Orsted Onshore Ireland Midco Limited

15: MEMORANDUM RESPONSE TO SUBMISSIONS RECEIVED

CUMULATIVE EFFECTS

Proposed Oatfield Wind Farm Project, Co. Clare: ABP
Case No. ABP-318782-24

Figure 12.9 Receptors and study area (cumulative scenario 2)

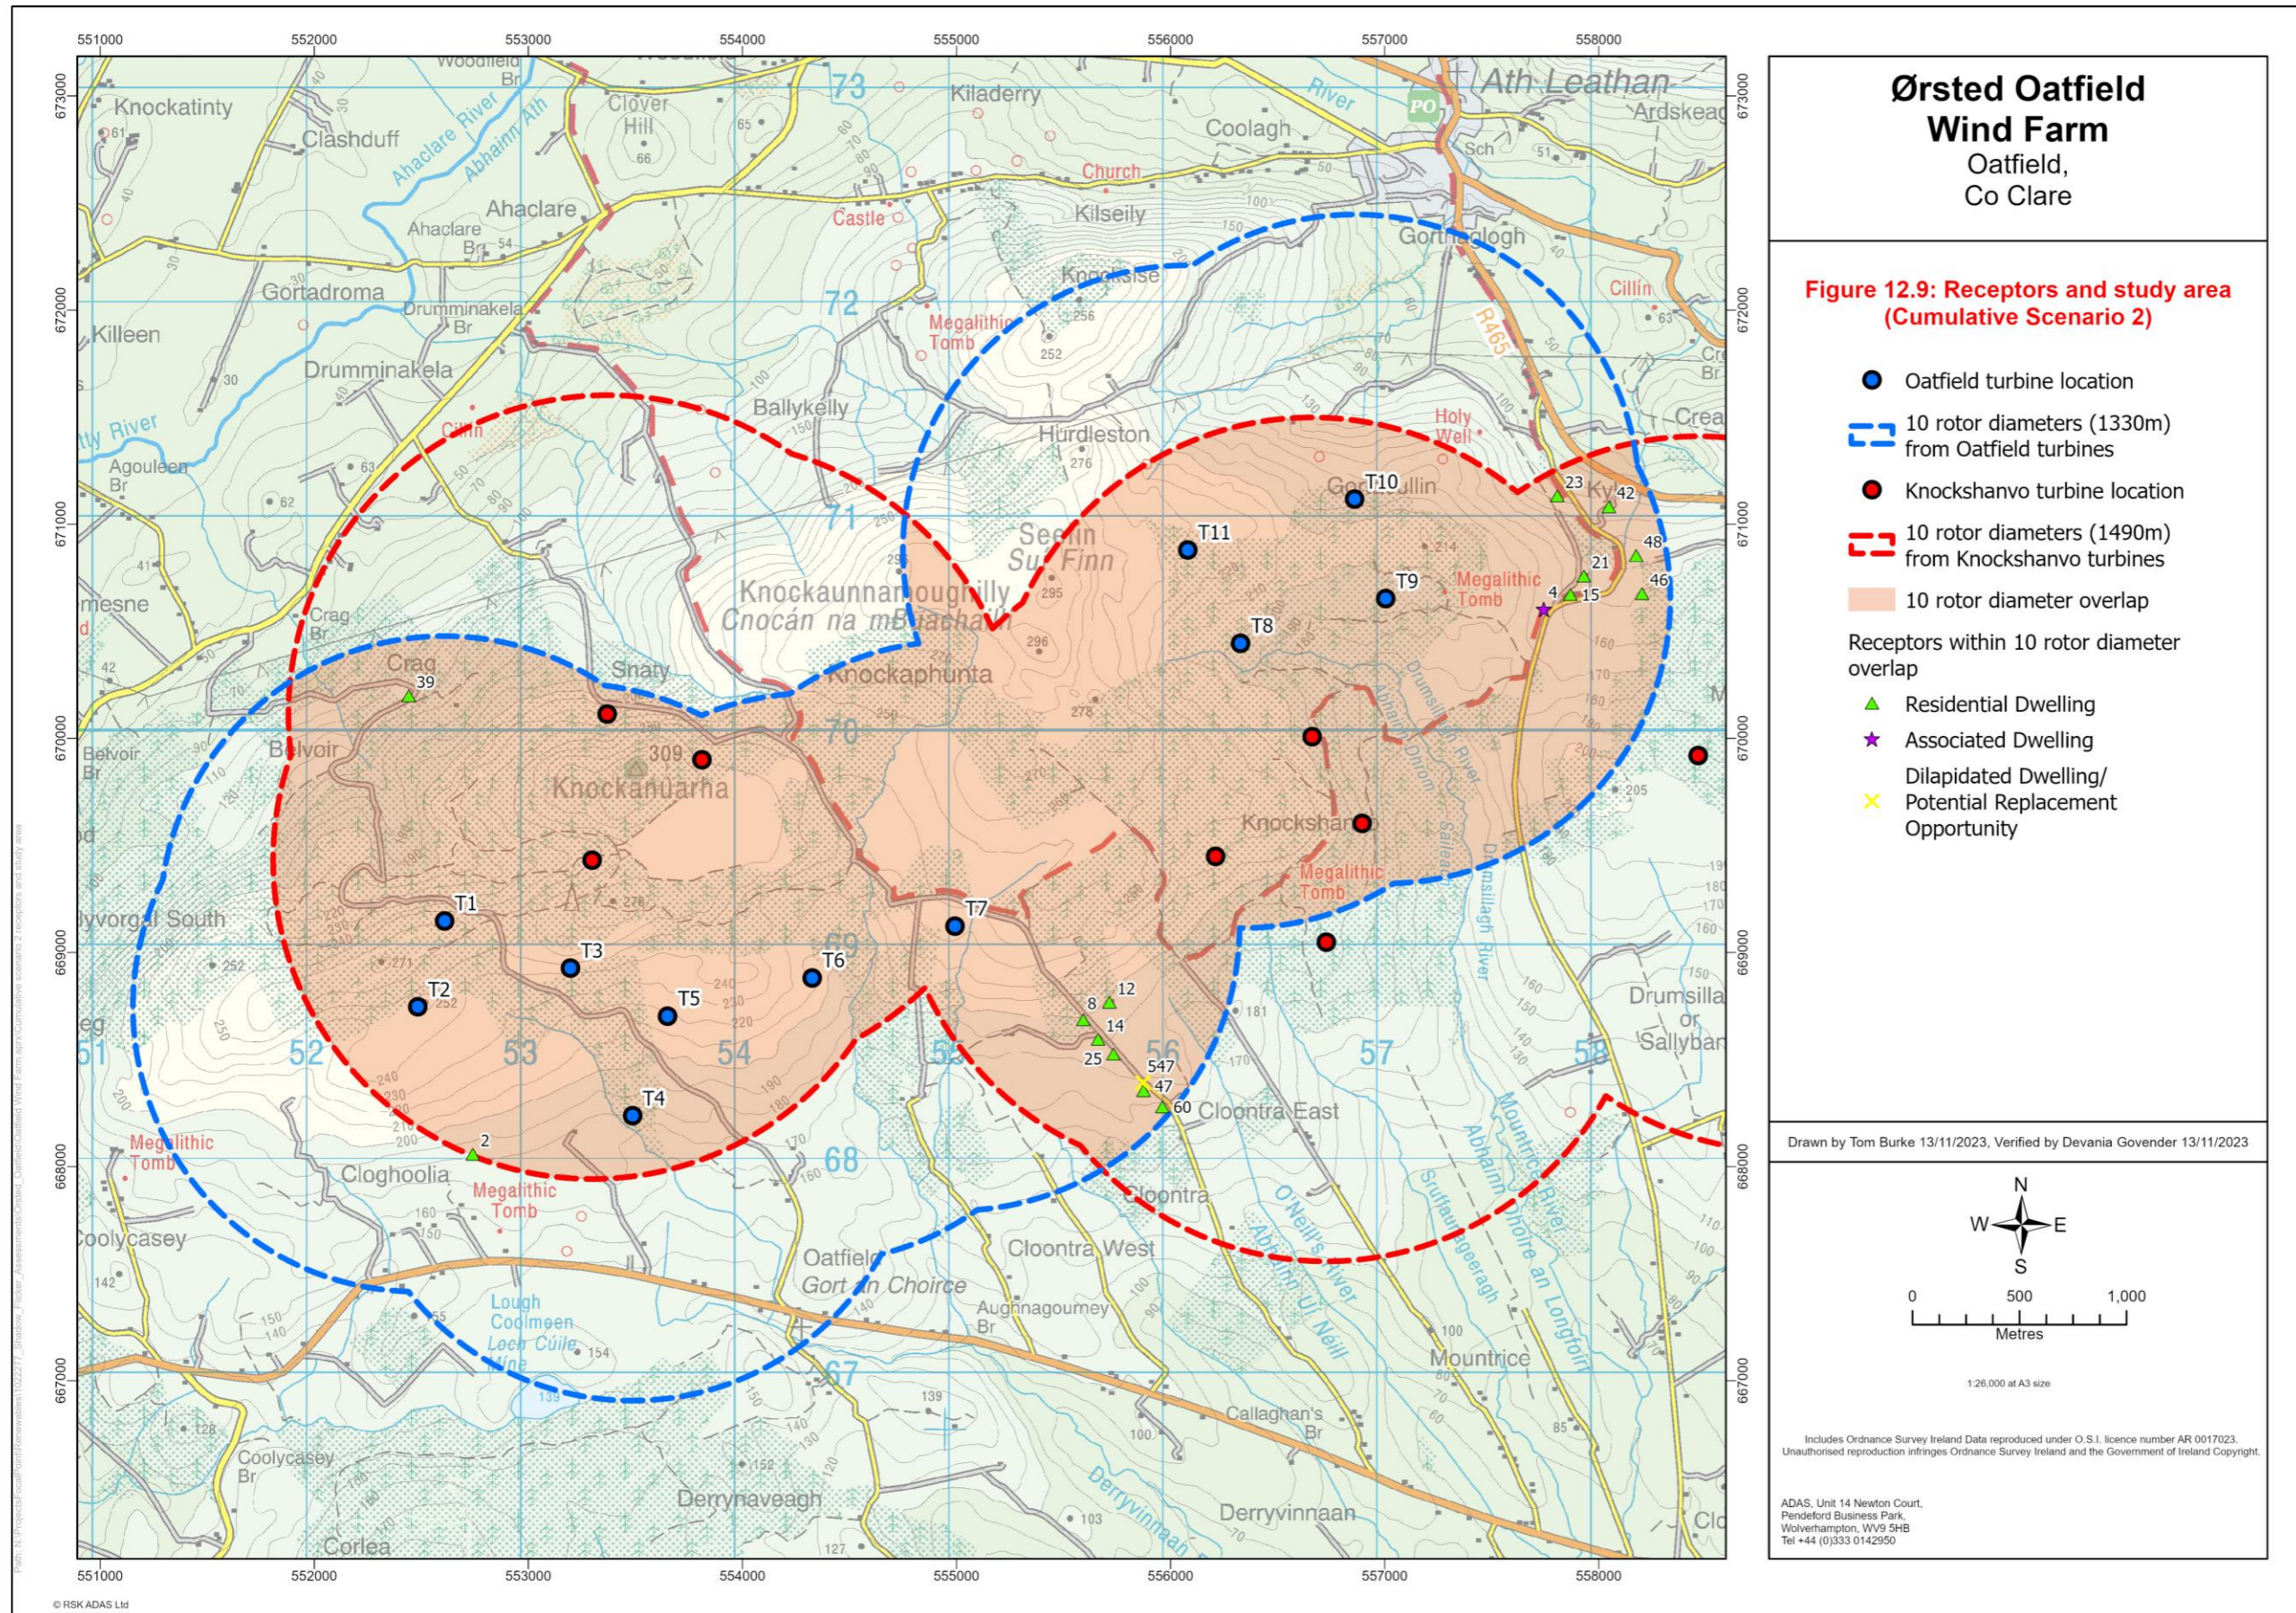
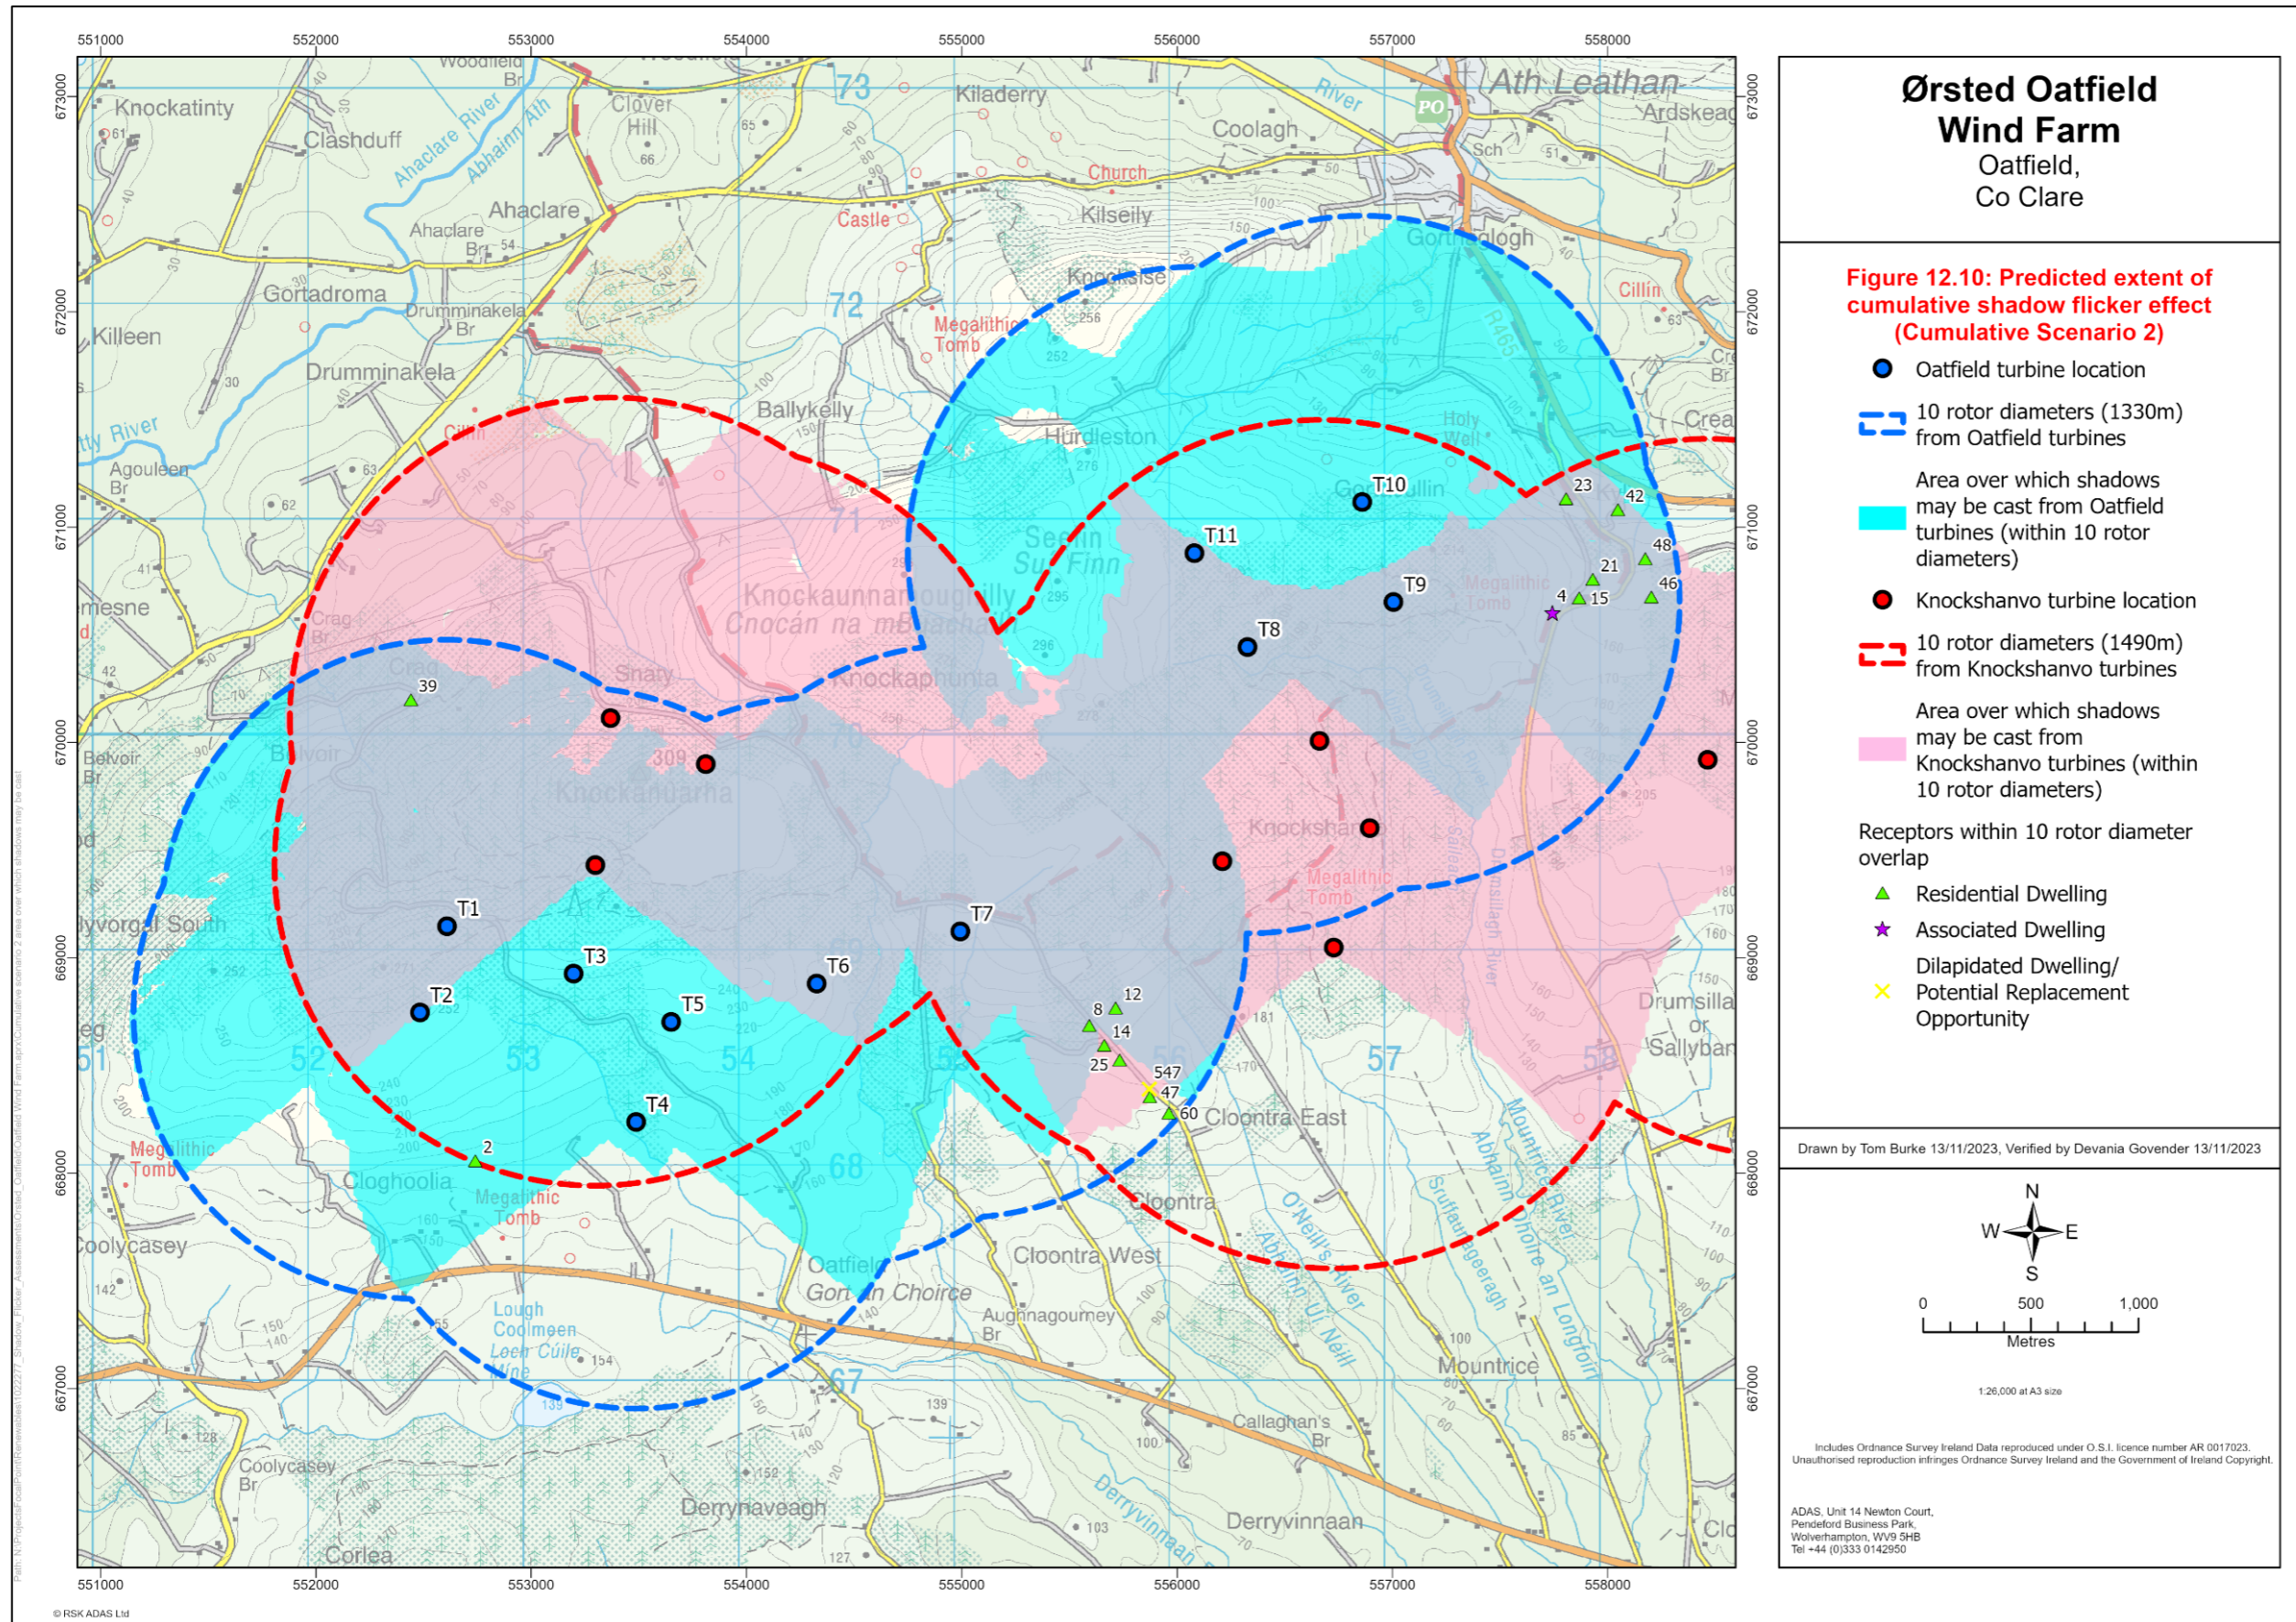
Several third-party submissions have raised concerns regarding the potential for combined shadow flicker impacts arising from the Proposed Development and the pre planning Knockshanvo Wind Farm.

Cumulative effects related to shadow flicker have been addressed in **memorandum no. 8**. Also, a thorough assessment of potential cumulative effects was conducted as part of the shadow flicker assessment presented in Section 12.9.1 of **EIAR Chapter 12**.

Potential cumulative effects were identified with the adjacent pre planning Knockshanvo wind farm and a cumulative shadow flicker assessment was therefore carried out, whereby the turbines of both the Proposed Development and the Knockshanvo wind farm were considered. At the time that the shadow flicker assessment was undertaken, the planning application for the Knockshanvo Wind Farm had not been submitted for planning, and no finalised detailed information is yet available. However, the planning application for Knockshanvo Wind Farm will likely consider the cumulative impacts from the Proposed Development, for which all relevant information has been submitted in the planning system. Nonetheless, **EIAR Chapter 12** for the Proposed Development presented an assessment of potential cumulative shadow flicker effects, using the latest known project details for Knockshanvo Wind Farm available at the time. As mentioned, it will be the responsibility of the Knockshanvo Wind Farm to demonstrate how it considers that Wind Energy Development Guidelines thresholds for shadow flicker can be achieved in practice through the cumulative operation of both sites.

At the time the shadow flicker assessment was conducted for the submitted EIAR, Ballycar Wind Farm was in the pre-planning stage, and proposed turbine locations and specifications were not publicly available. The planning application for Ballycar Wind Farm has since been submitted. Examination of the shadow flicker assessment carried out as part of this indicates that the 10 x rotor diameter shadow flicker study area for Ballycar Wind Farm does not overlap with that of the Proposed Development. There is therefore no potential for cumulative effects.
